10 September 2021

**Sutherland Hospital Operating Theatre Upgrade (SSD-11099584)
Request for additional information**

LANDSCAPE PLAN - CANOPY COVER

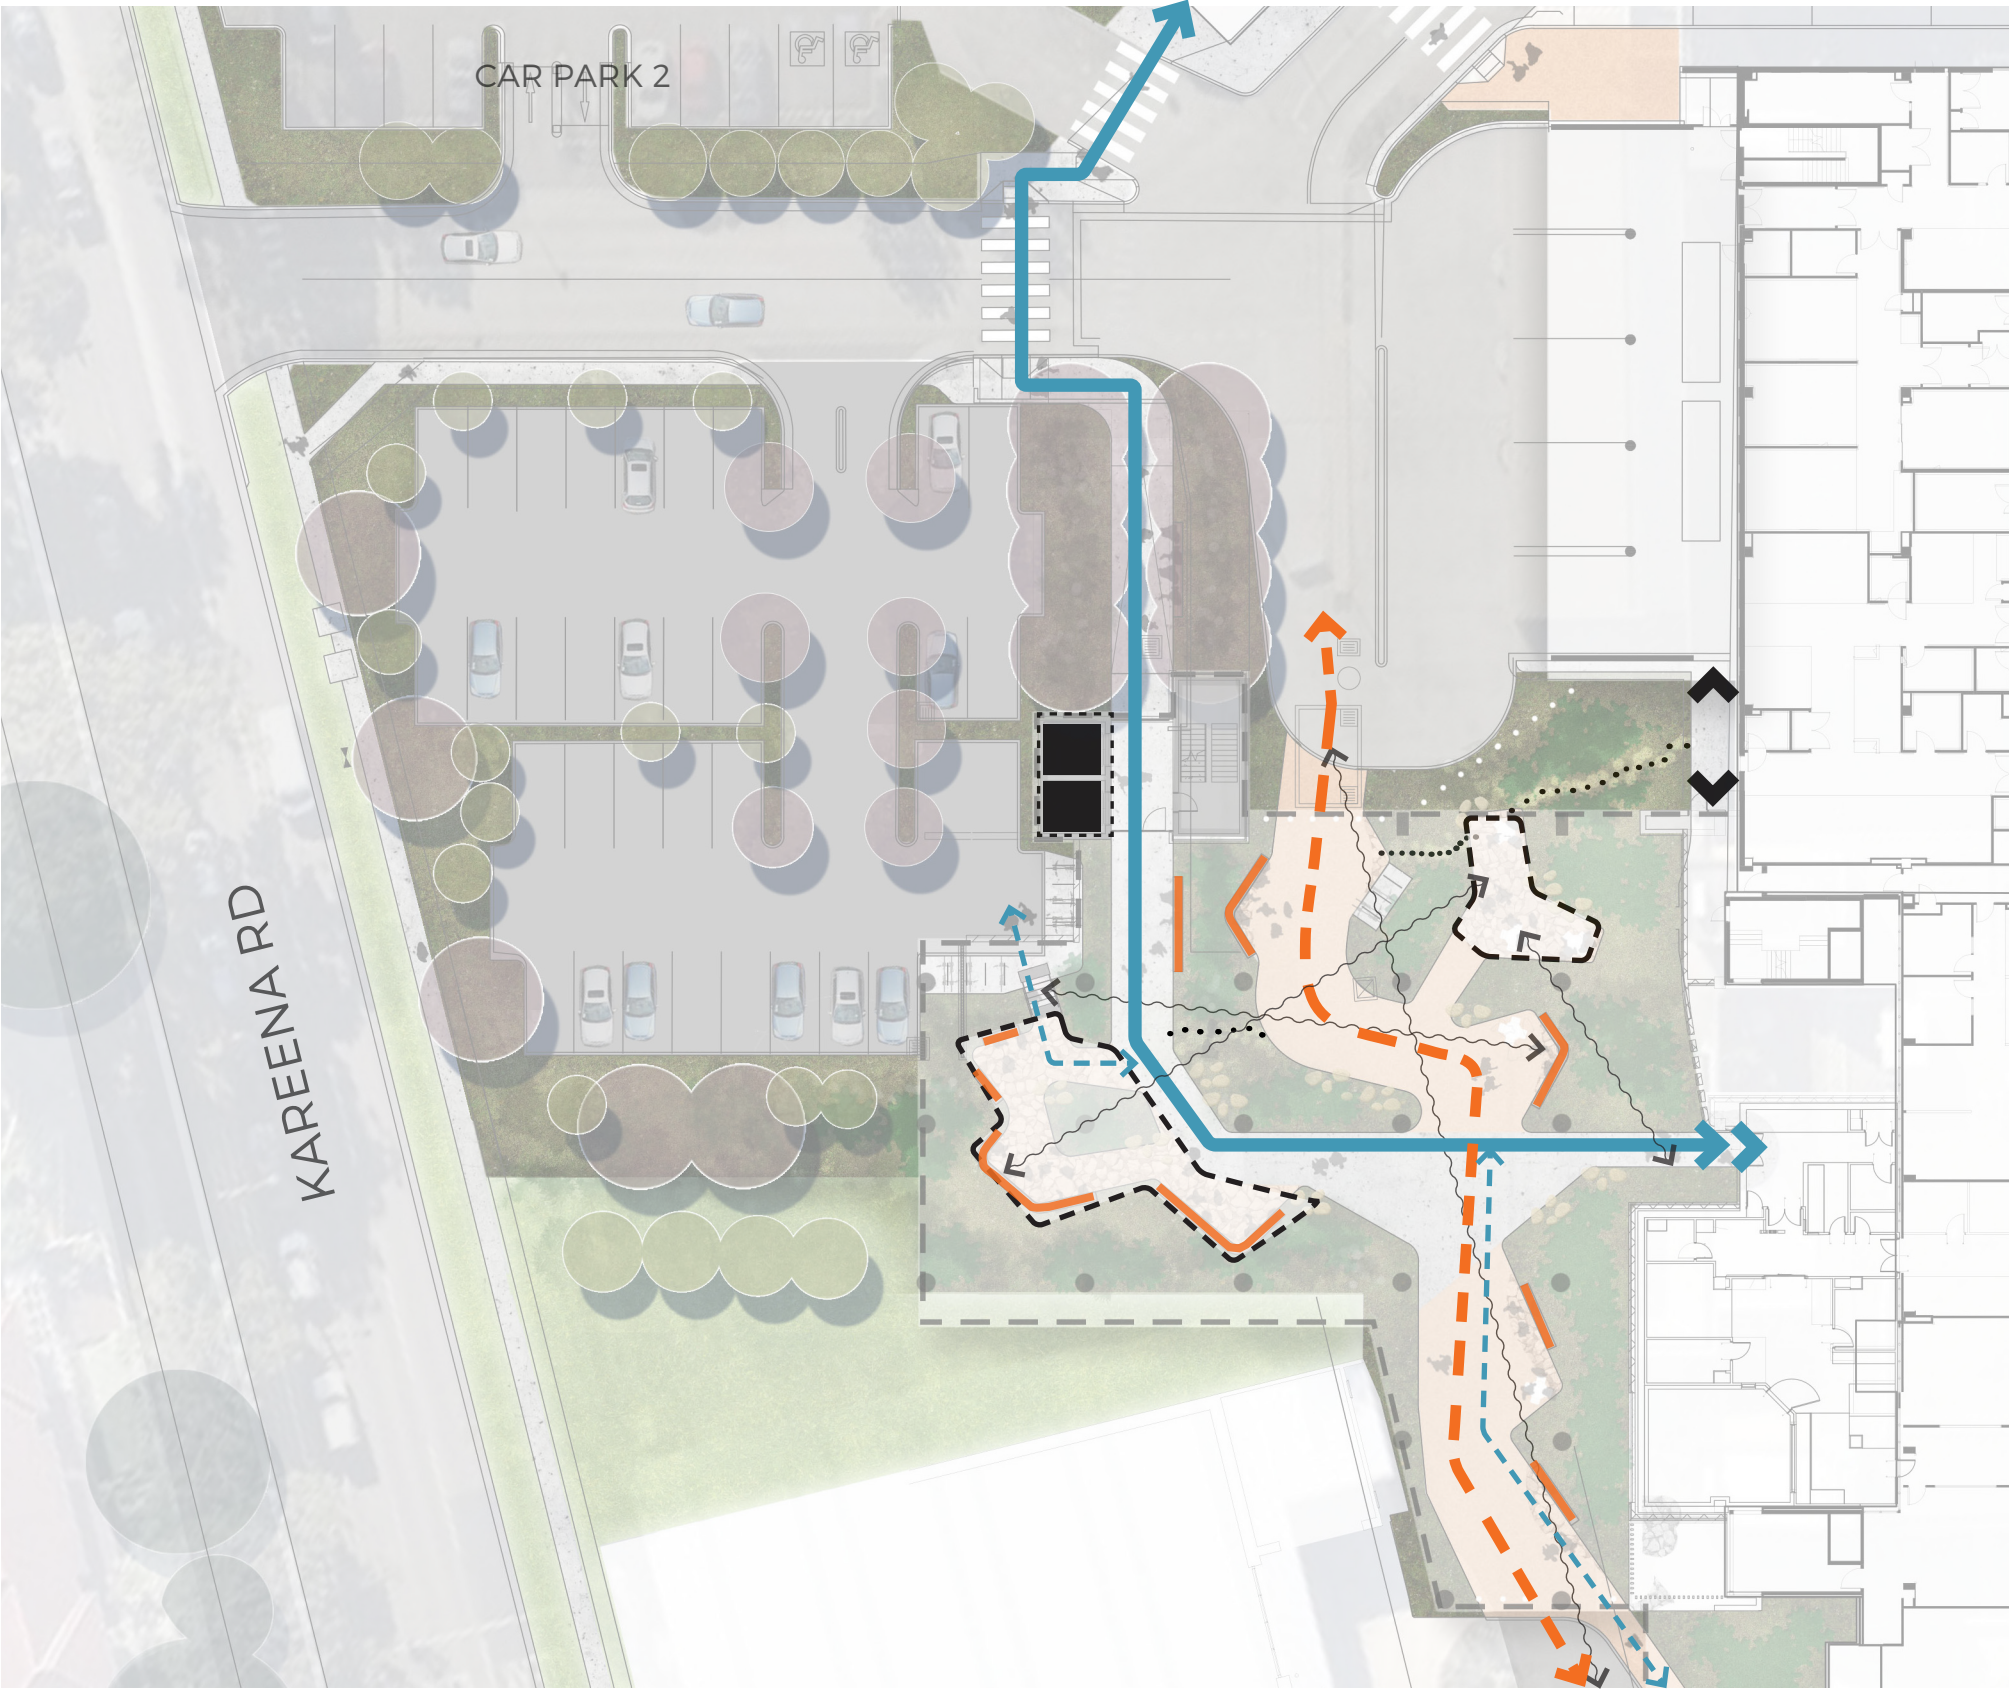
- confirm the total number of trees to be removed, and provide a single plan that clearly depicts all trees to be removed and all trees to be protected and retained. Please note that the information relating to tree removal provided to date has been inconsistent, for example:

- landscaping plans show 10 existing trees are to be removed.
